Recommendation Report for Planning Permission for Works or Extension to a Dwelling

REF NO: Y/66/22/HH

LOCATION: 29 West View Drive
Yapton
BN18 0JR

PROPOSAL: Erection of single storey front extension.

DRAWING BLOCK PLAN DATE: MAY 2022 DRAWN: T. Murray	SCALE 1/500@A3
DRAWING: 22/35/3	REVISION:

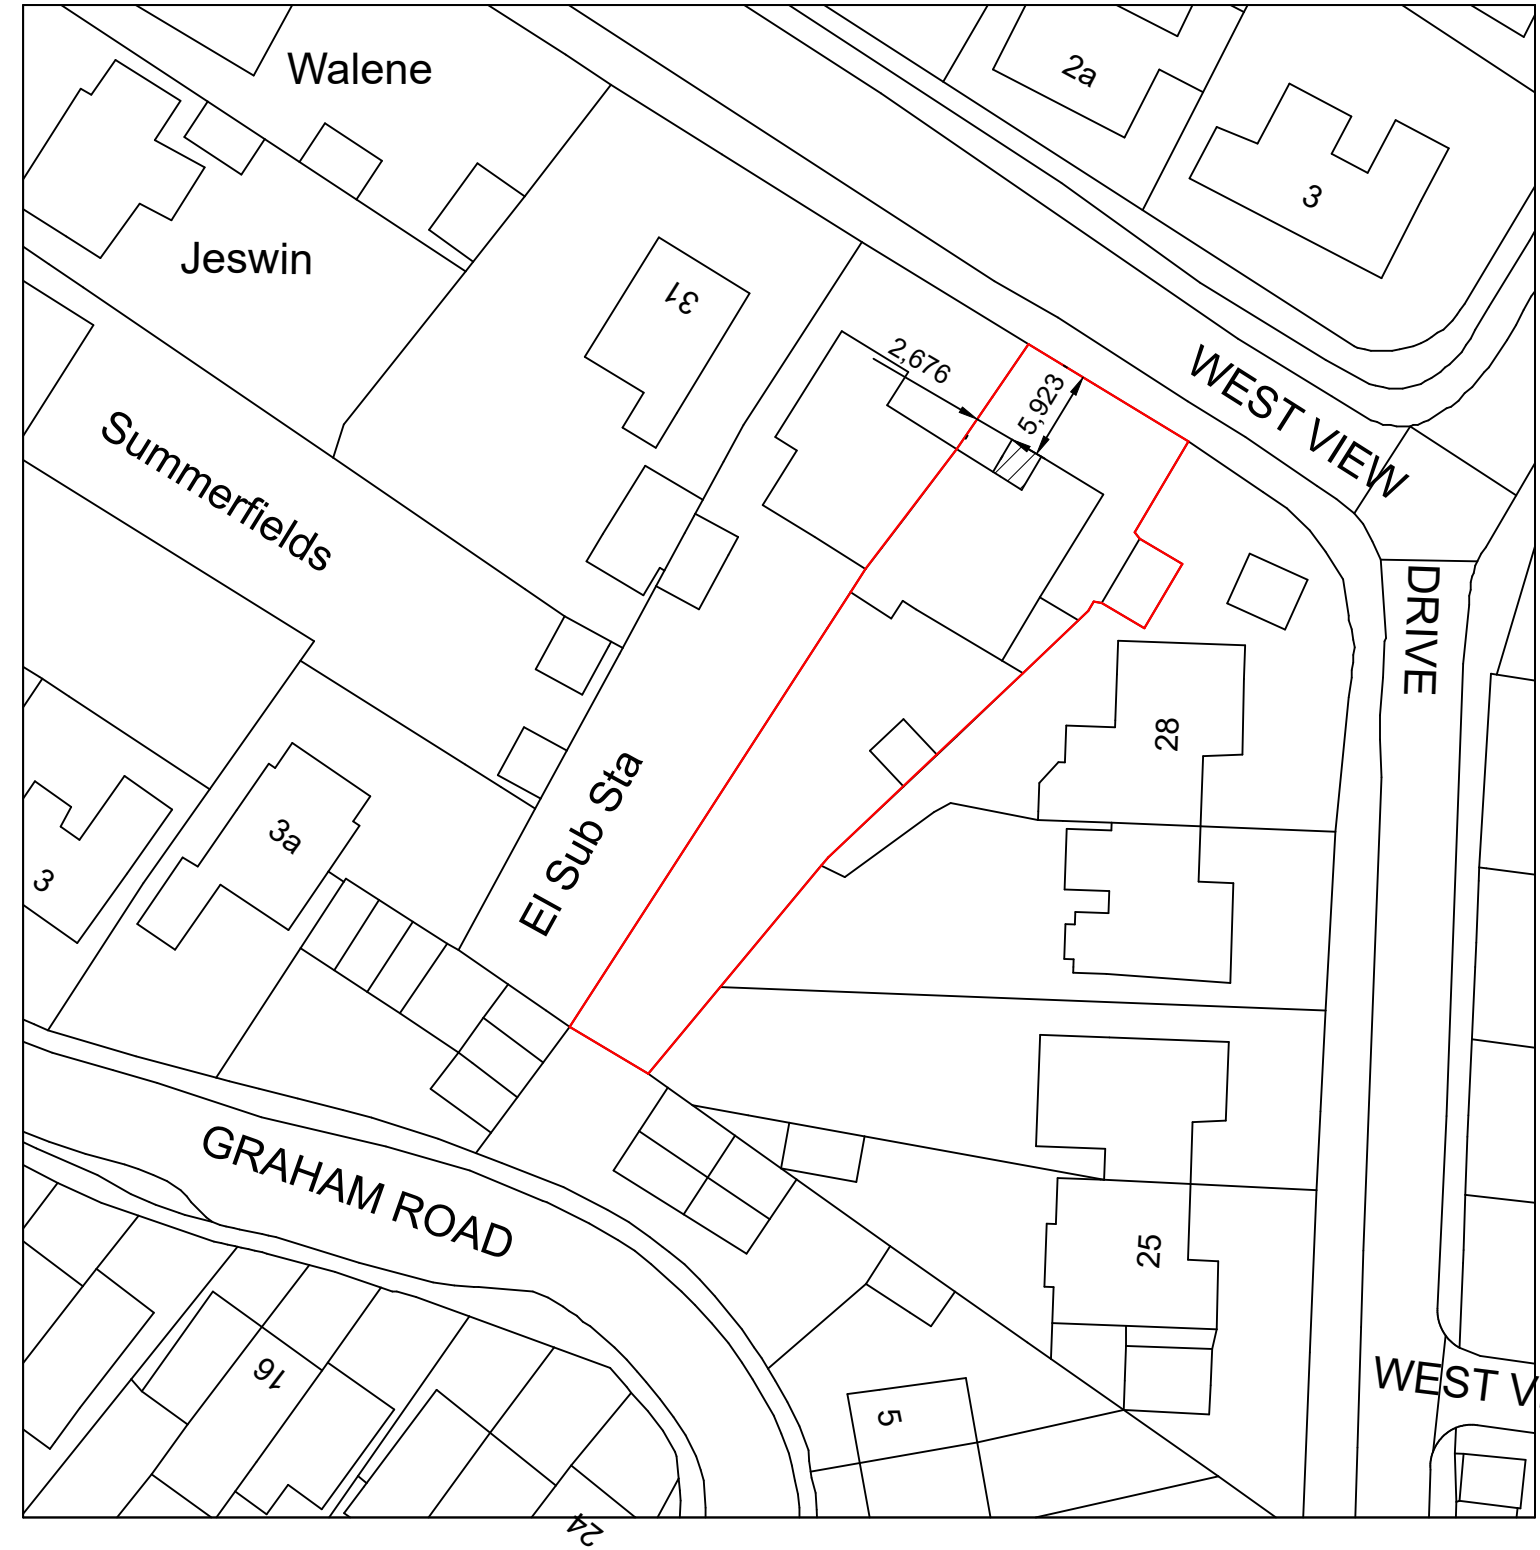
The proposal will be single storey and have a pitched roof measuring approximately 3.2m high and 2.4m at the eaves. It will retain 2.676m to the northwest boundary, and 5.923m to the northeast. These

DRAWING PLANNING DATE: MAY 2022 DRAWN: T. Murray	SCALE 1/100@A2
DRAWING: 22/35/2	REVISION:

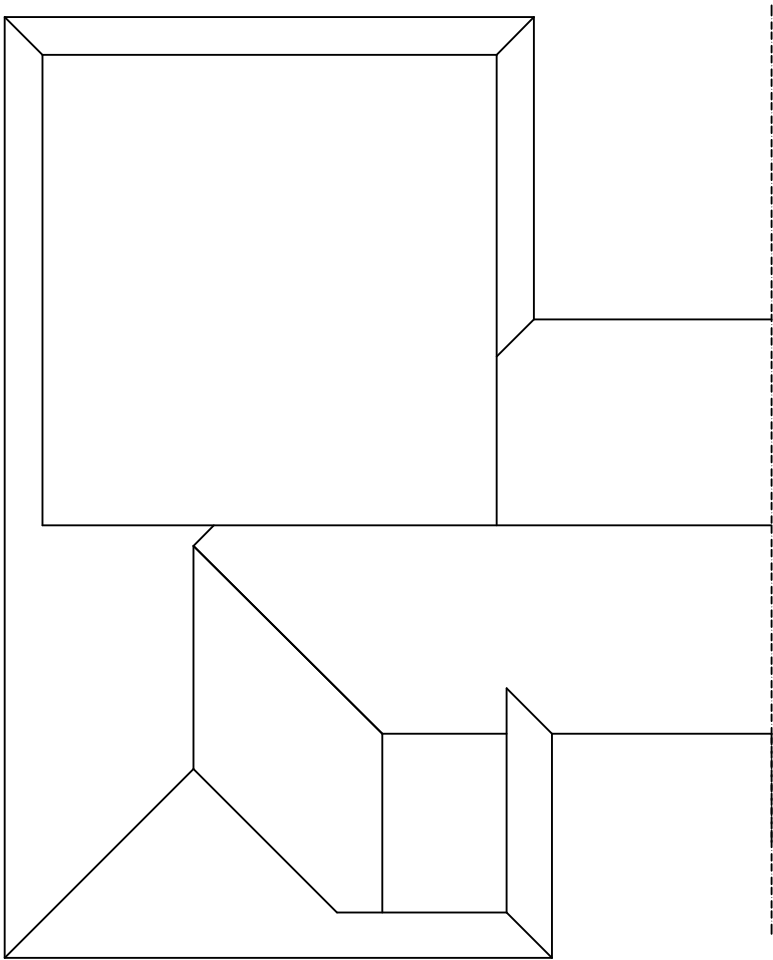
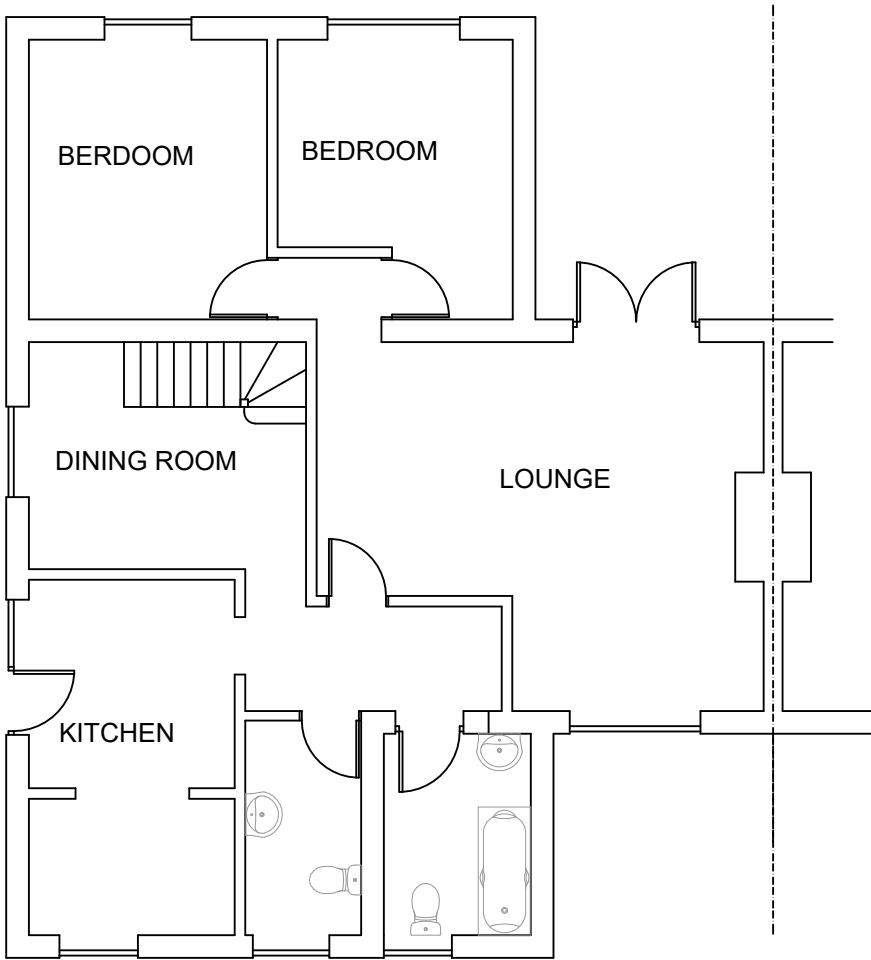
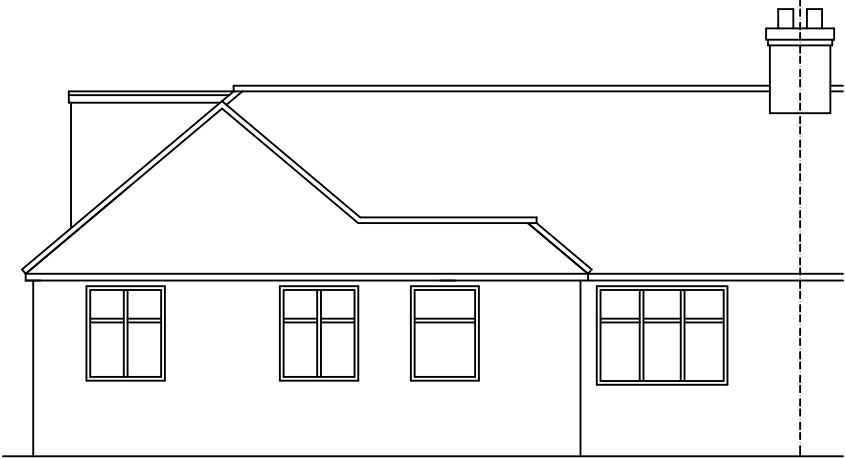
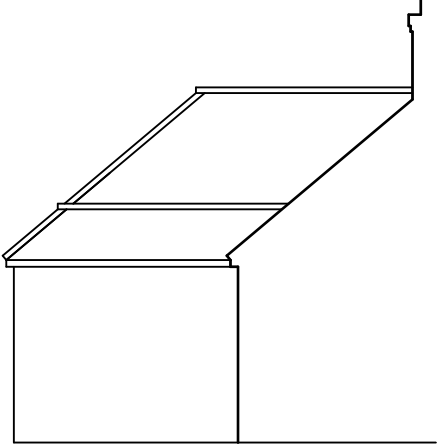
The extension will replace a porch to the front elevation. It will retain the existing footprint, measuring approximately 2.25m wide and 2.96m deep, and line up with the established building line of the principal elevation. The extension is an acceptable replacement, and will improve the appearance of the front elevation, replacing an existing flat roof with one that is pitched, of which will integrate more sympathetically with the dwelling. This will appear in keeping with the character of the property and have minimal harm on its visual appearance. Being to the front, the proposal will be visible from the street scene. It will have minimal impact on the composition and appearance of the street however, given its scale and more appropriate design for the host dwelling, and will instead be an improvement to the street scene. It will remain in keeping with the character of the area and have little harm on visual amenity.

The extension appears subservient to the design of the host and is well integrated. The materials used will match the existing, ensuring minimal intrusion on visual amenity. It is appropriate in terms of scale and massing and will not be unduly obtrusive or dominant on the host dwelling.

The proposal features the installation of a single window to the northeast (front) elevation. This window will not overlook any neighbouring properties, instead facing the road, and will have no impact on residential privacy or amenity.
